Boston Alternative Energy Facility

Response to Environment Agency's queries on Critical Infrastructure and Levels across the Application Site

Document Reference: 9.40

Date: 06 December 2021

TITLE
**BOSTON ALTERNATIVE ENERGY FACILITY
DEVELOPMENT CONSENT ORDER
Regulation 5(2)(o) - Indicative Wharf Plans
BOSTON BOROUGH COUNCIL
SHEET 1 OF 3**

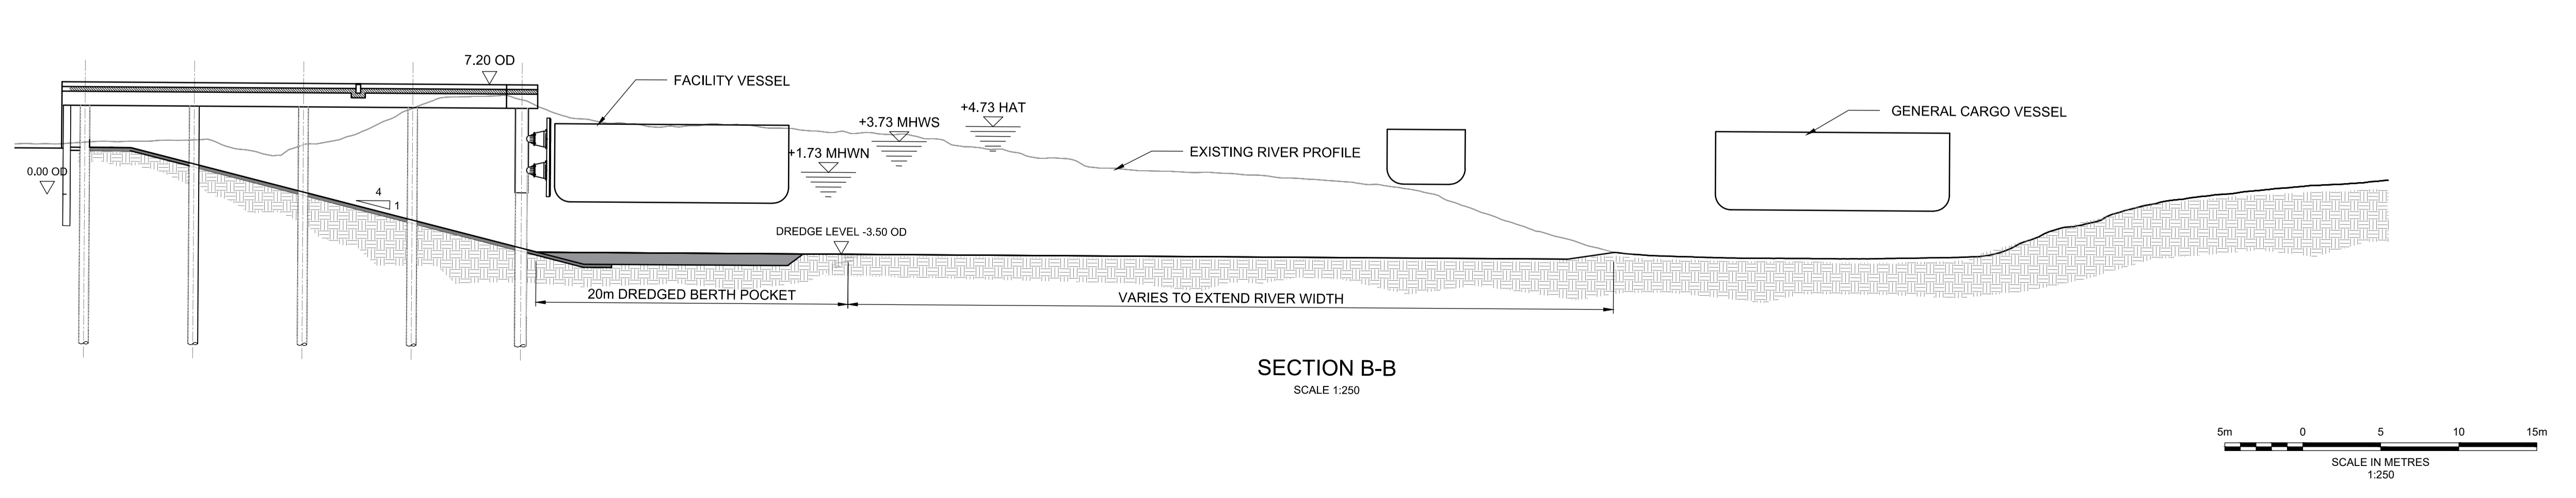
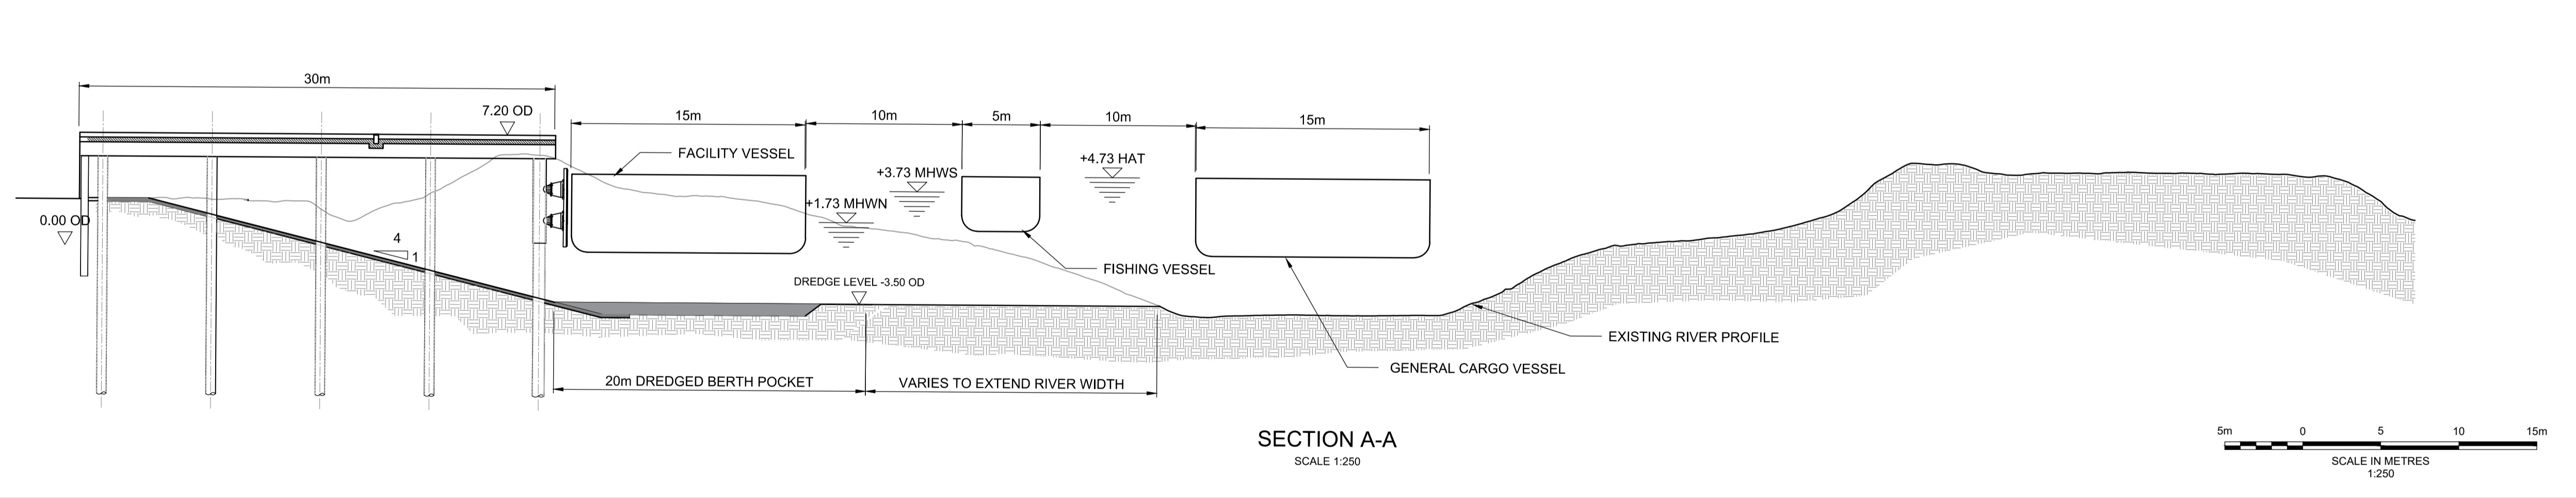
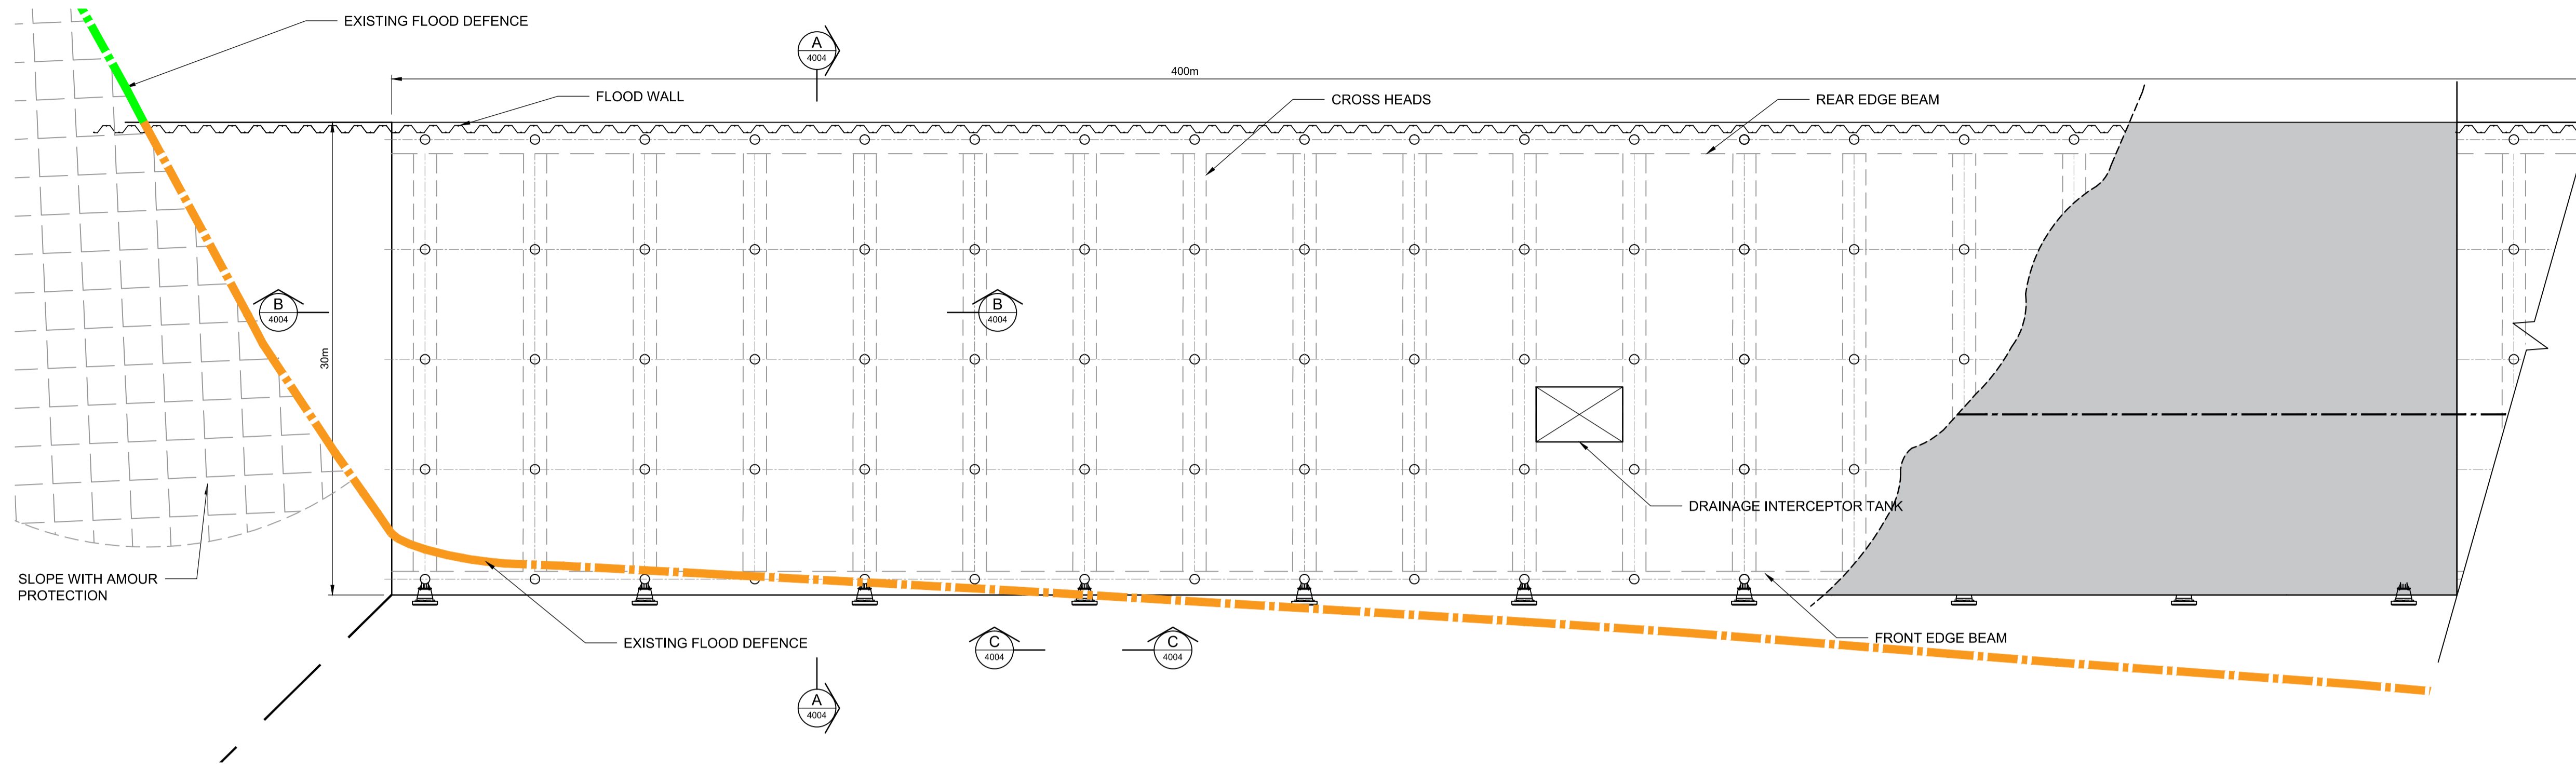
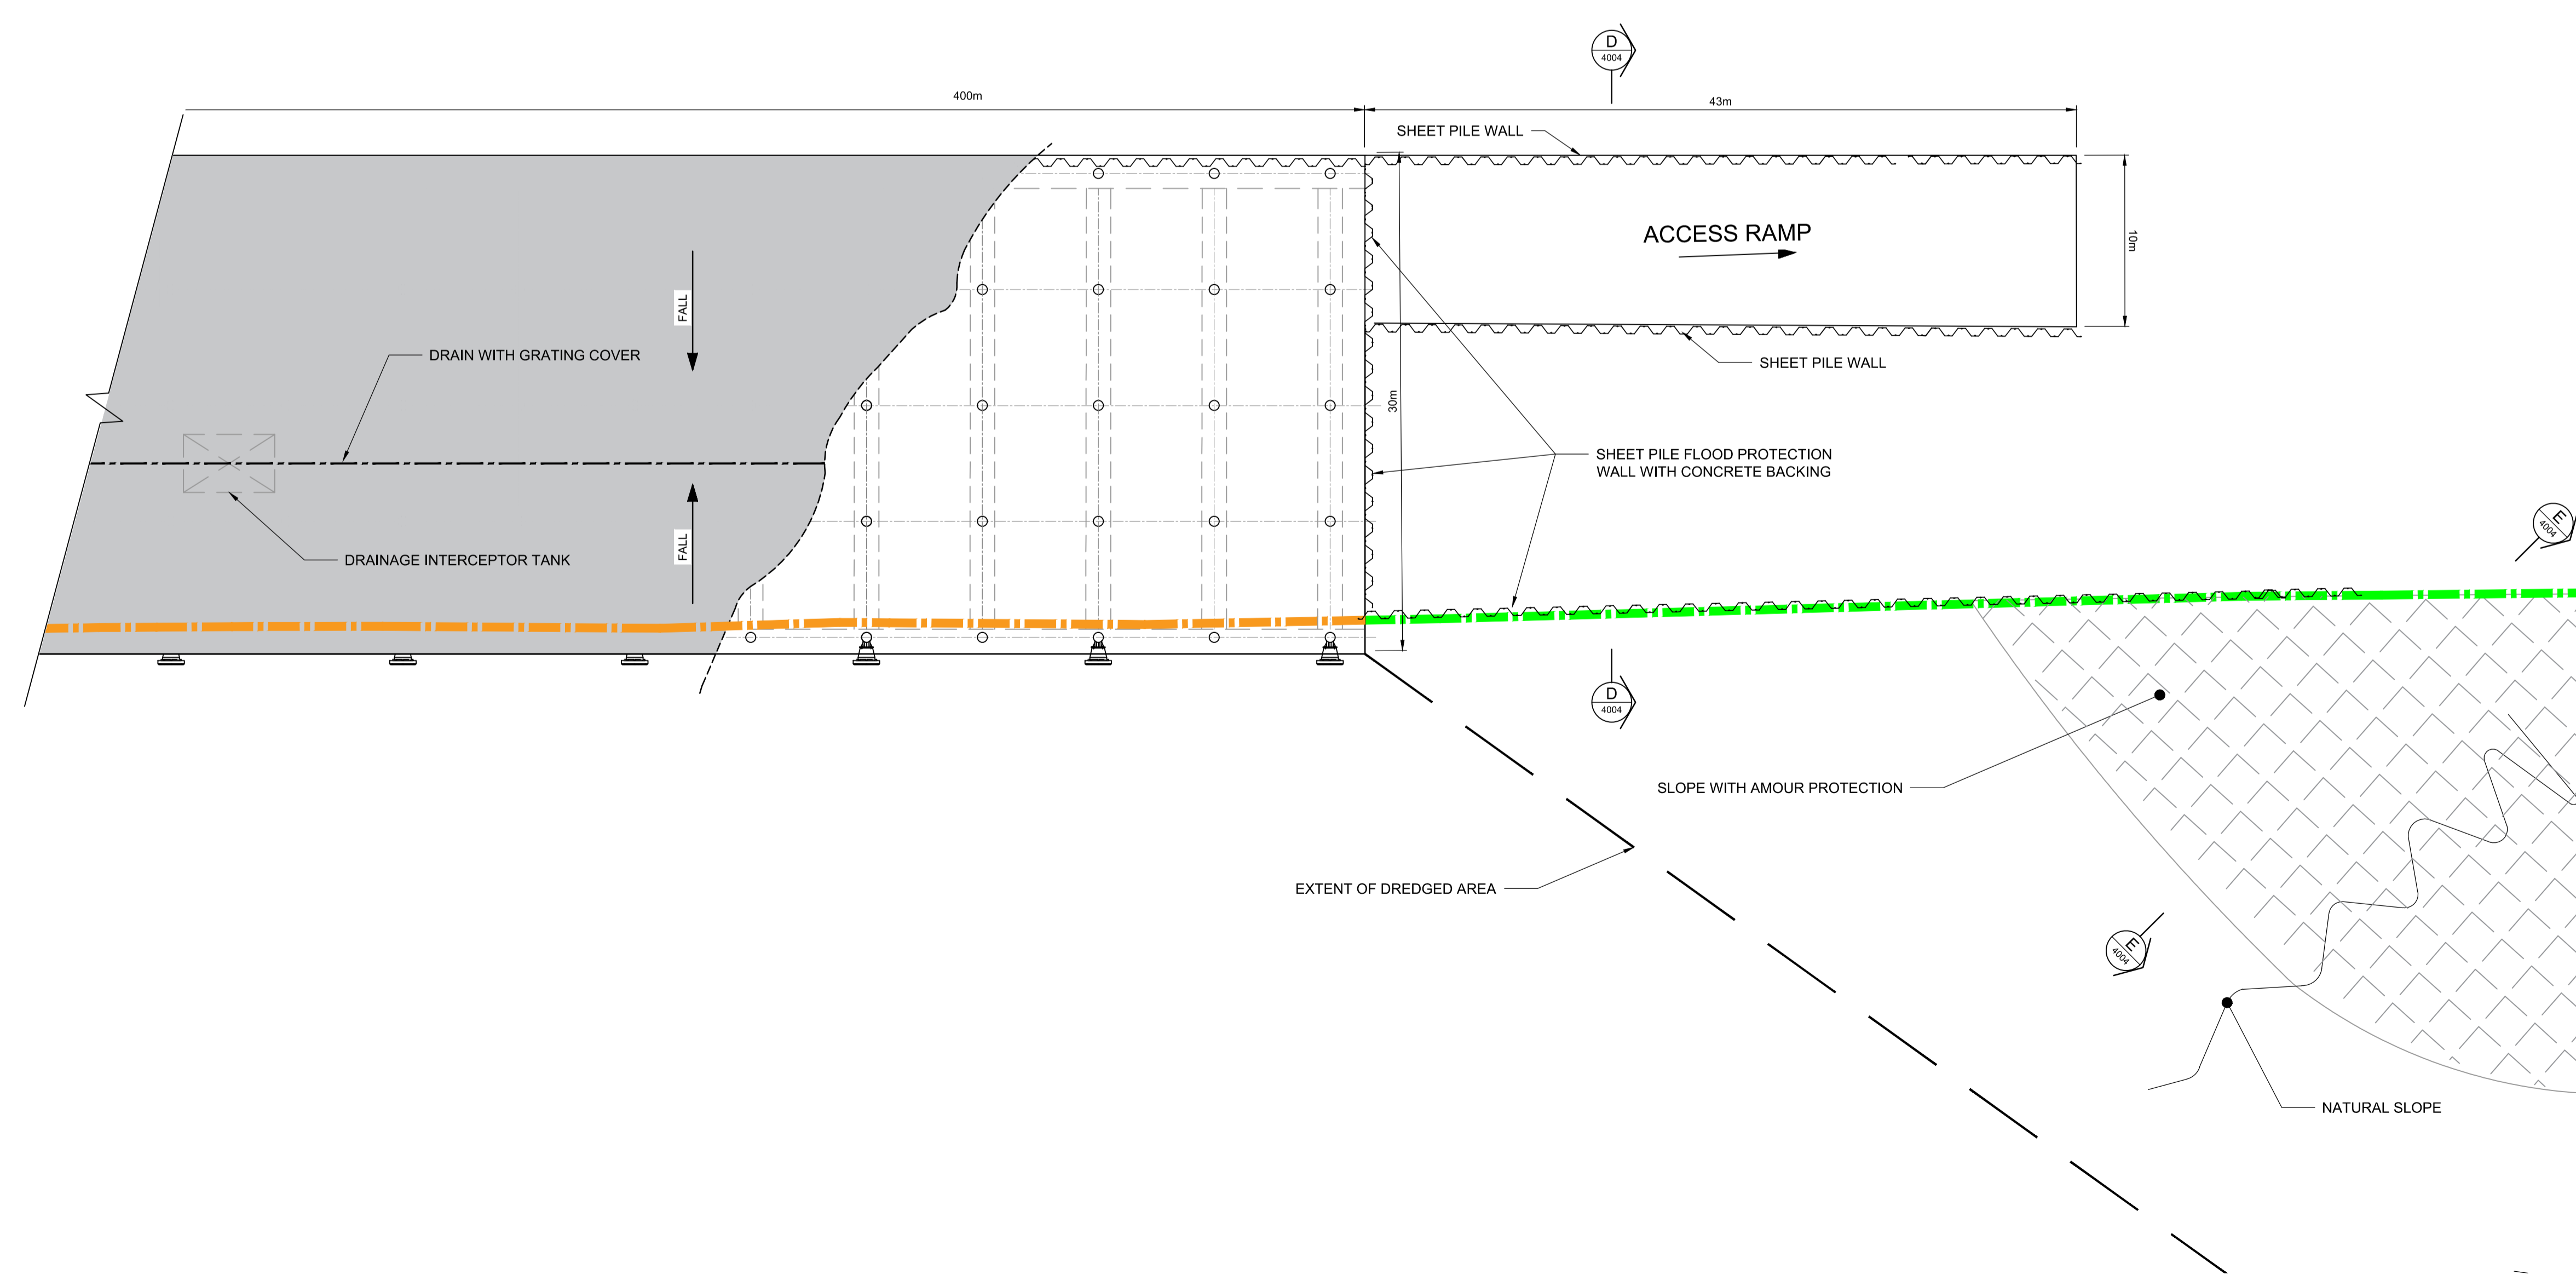
- 3.3 *We require details of finished site levels including assessment of any impact on the flow of water over the site. The Applicant has indicated to us that approximately 0.5 m of surface material will be removed and replaced with 0.8 m of surcharged material across the main site. This gives a net gain of 0.3m over the whole site. We require further assessment of the impact on flood risk to third parties through the displacement of flood waters.*

Furthermore, the Applicant notes in the Comments on Written Representations (document reference 9.22, REP2-006) that the Facility will be protected by the new flood defence along the frontage of the Principal Application Site, which will be set to +7.2m AOD (i.e. the maximum level of that proposed for the wider Haven Banks Project) from the outset of the Project.

Therefore, the Applicant notes that, unlike defences along the wider Haven Banks frontage, there will be no requirement to increase the crest height of the new flood defence as part of the Environment Agency's wider adaptive management approach. Until such time as the adaptive management approach is fully implemented the Project provides improved protection against flooding compared with that provided in the wider area.
